Lawful Development Certificate for a Proposed Use or Development

Development: Lawful development certificate for the erection of a proposed cabin.
Location: 26 Ford Road Arundel BN18 9EQ

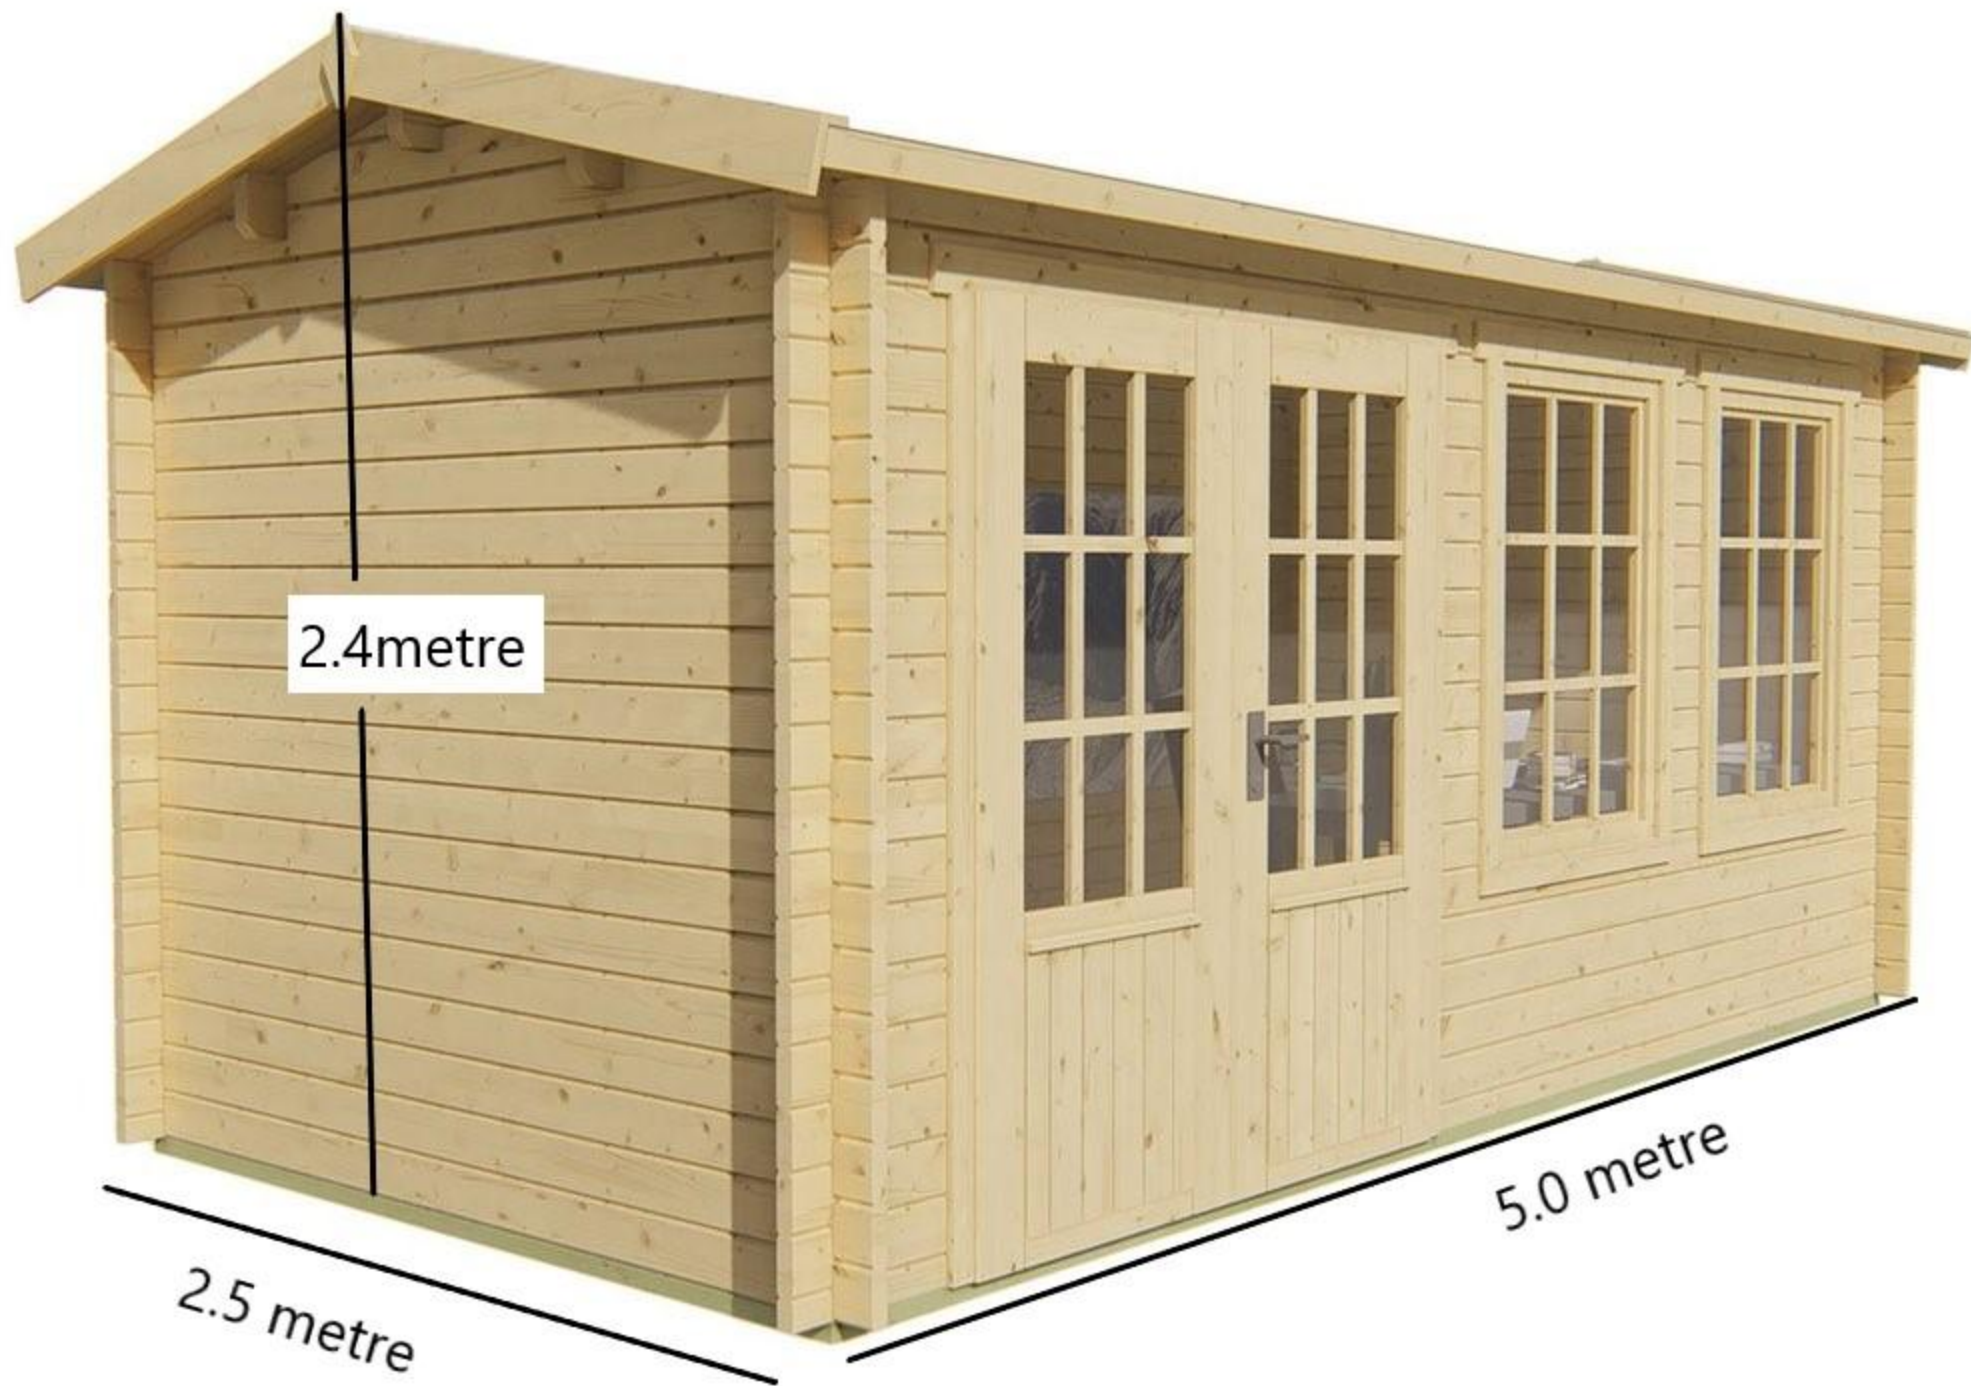
Please amend your site / garden plan to show the distances from the proposed cabin to the site boundaries.
